RE: Harnett Co Land Use Application # 09-5-21877

Based on my site visit regarding your request for a 16 x 36 pool these are my recommendations for you:

#### Septic System Layout

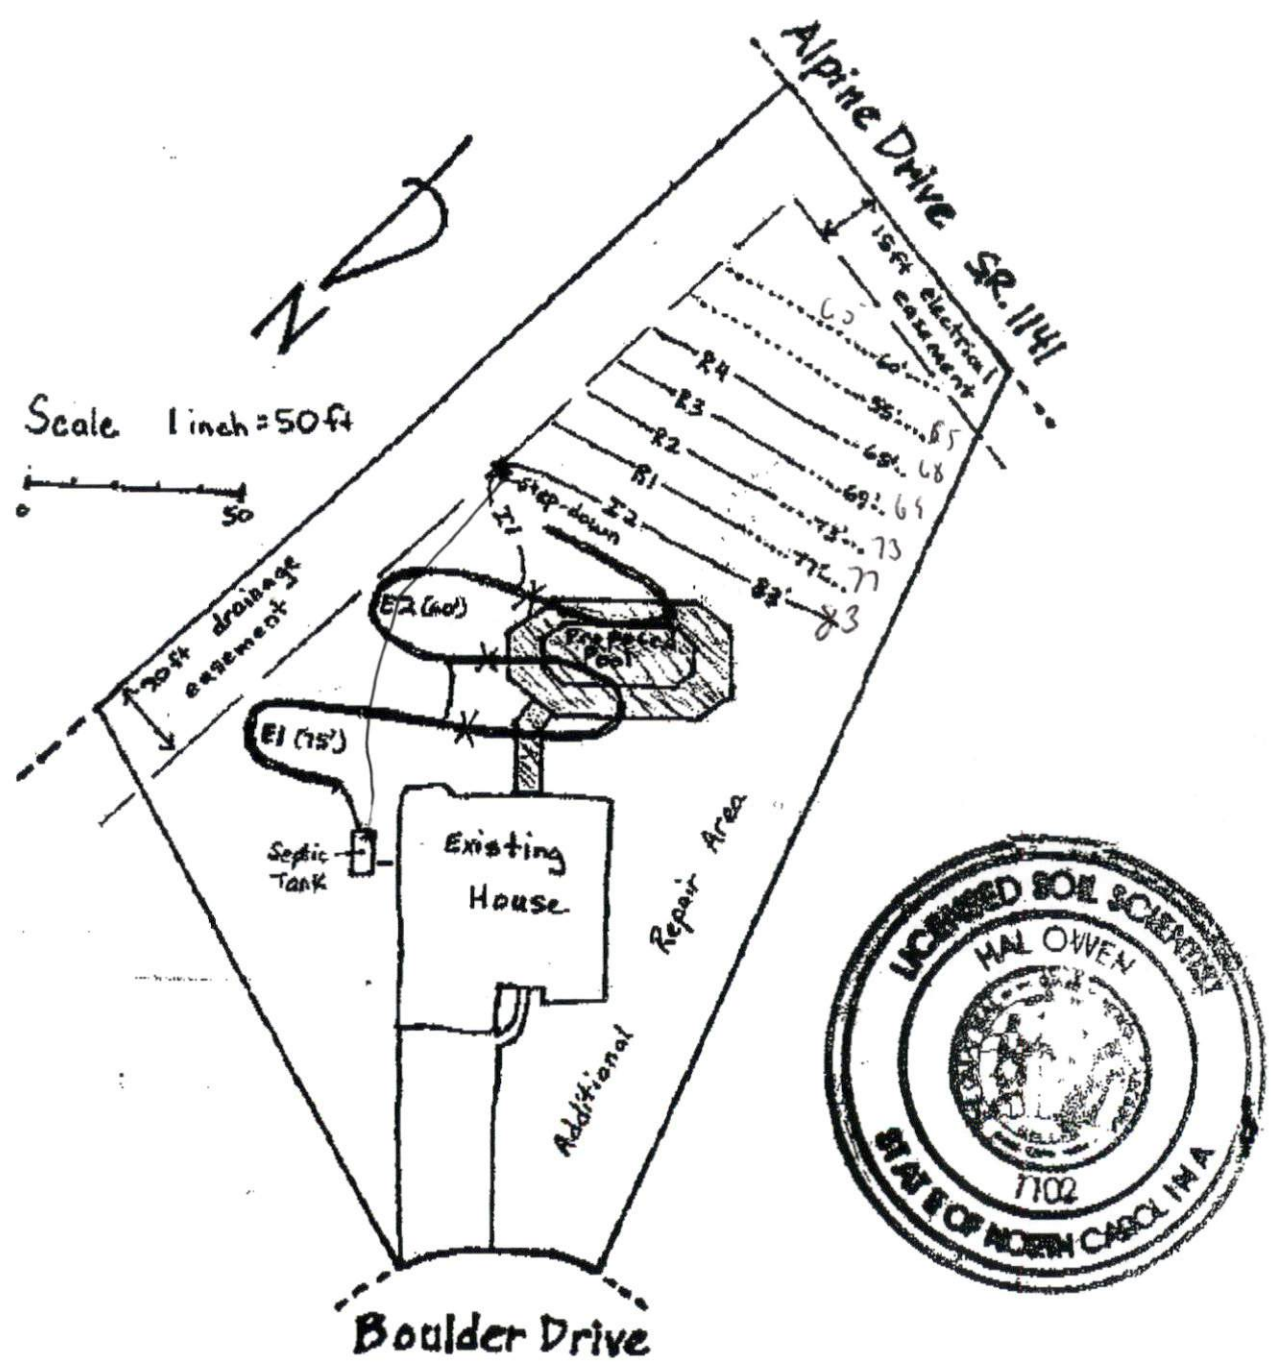
- Option 1 – Follow your consultant's suggestion and cut drain lines so they are 15 feet from the pool and add the amount of drain line lost to the end of the line as the consultant has shown. The amount of line added to the end will be unknown until work begins and we know how much line is lost to setbacks from the pool and how much is damaged digging the system up. You may want to have your septic contractor give you a price on this.
- Option 2 – Start at the septic tank and hard pipe (PVC pipe) down to the area below the pool and 15 feet from the pool and install 240 feet of new drain lines. The new drain lines would be installed as shown on your consultant's report.
